From: Anita Gardner <Anita.Gardner@arun.gov.uk>
Sent: 19 February 2021 11:54
To: Planning.Responses <Planning.Responses@arun.gov.uk>
Subject: FW: LU/23/21/DOC

The agents have submitted a drainage report setting out their measures for foul and surface water disposal at the site but do not discuss measures required to divert sewer as required by condition which is being refused. But with regard to condition 8 in the response you do not comment on the measures proposed in paras 2.2 of the report.

Appendix C
Drainage Layout

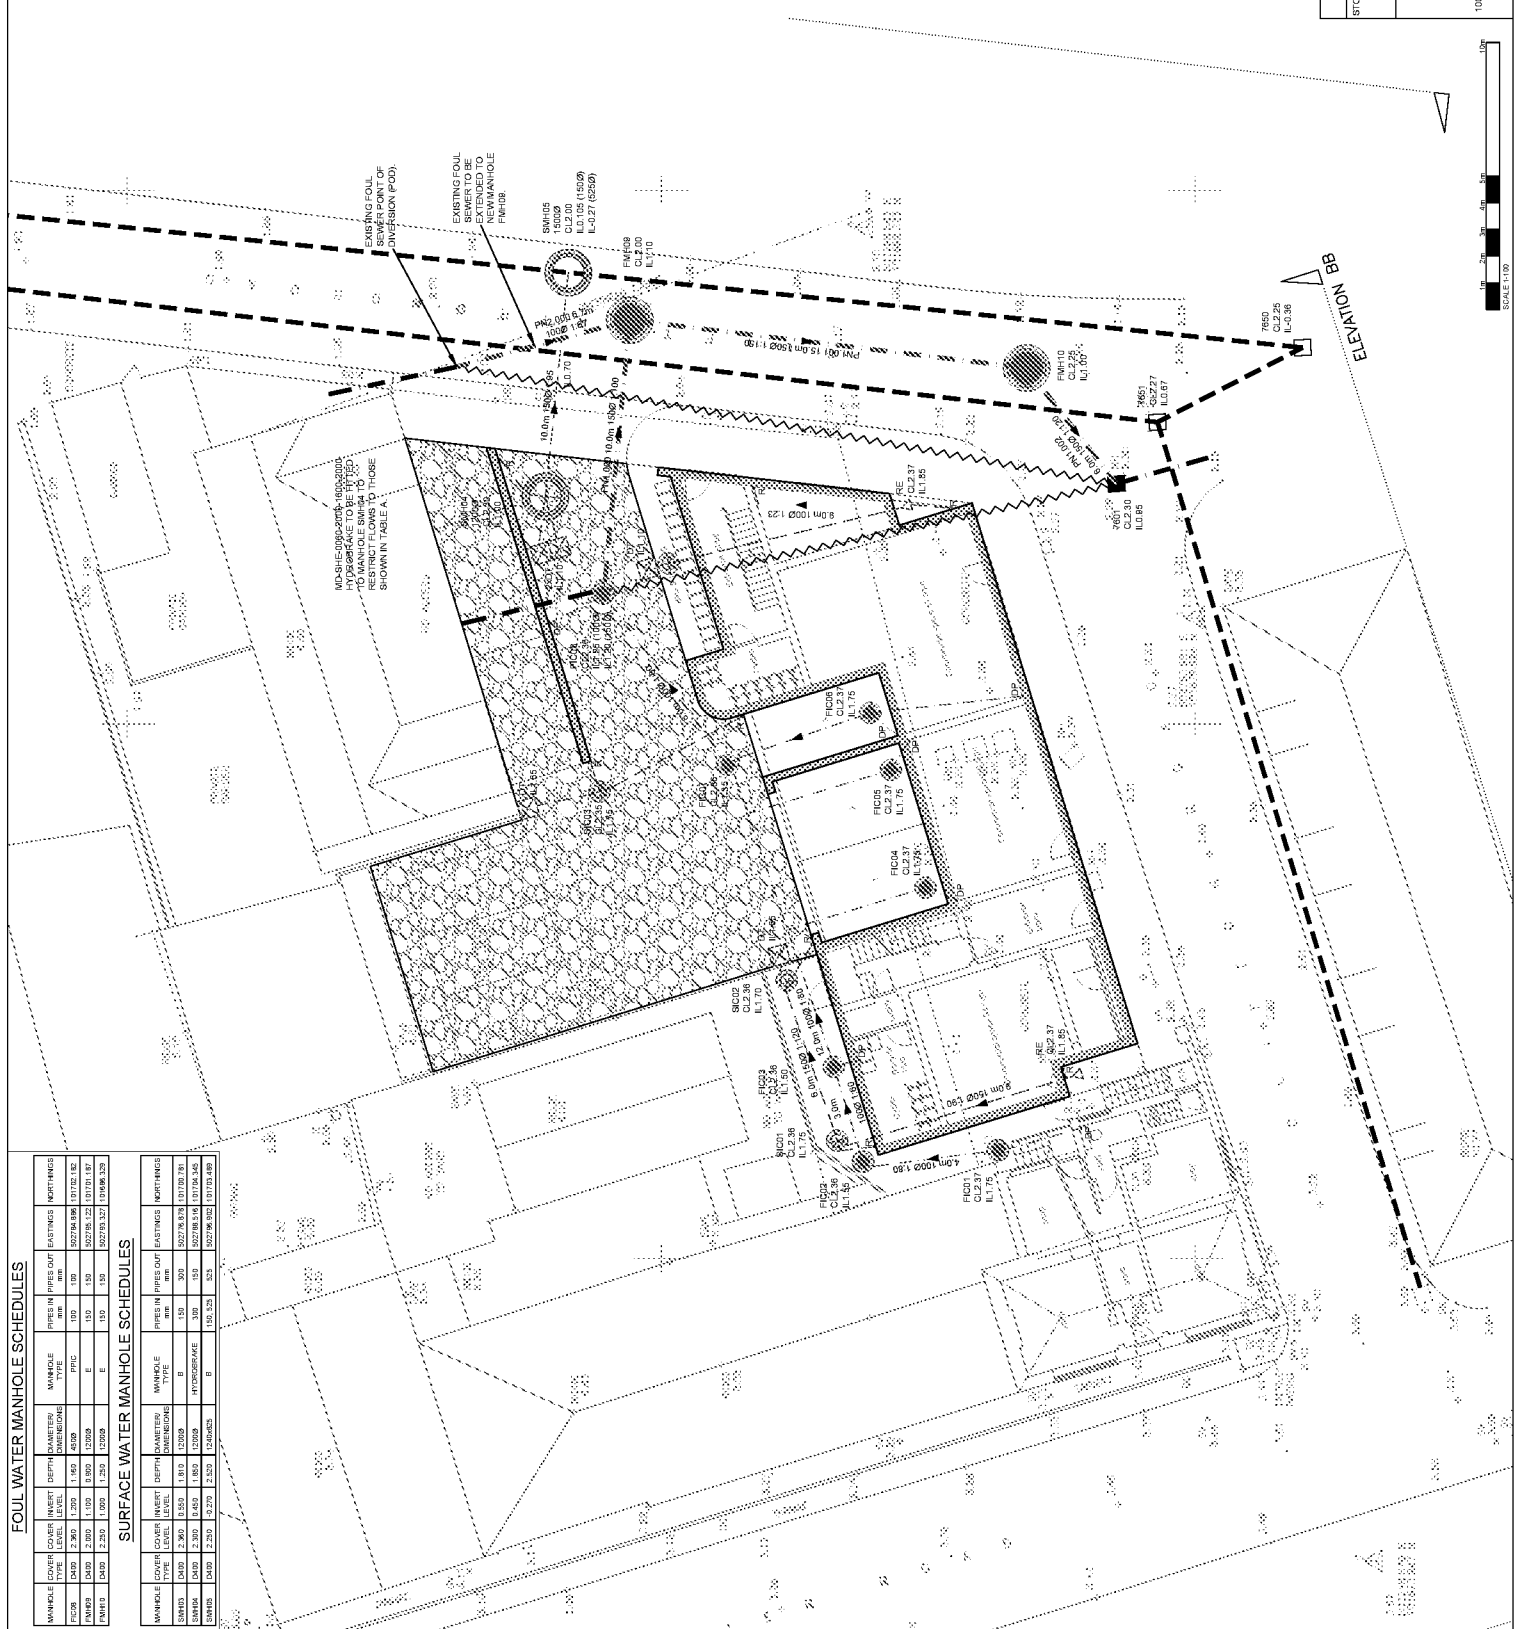
Could you advise if you are in agreement with the measures?
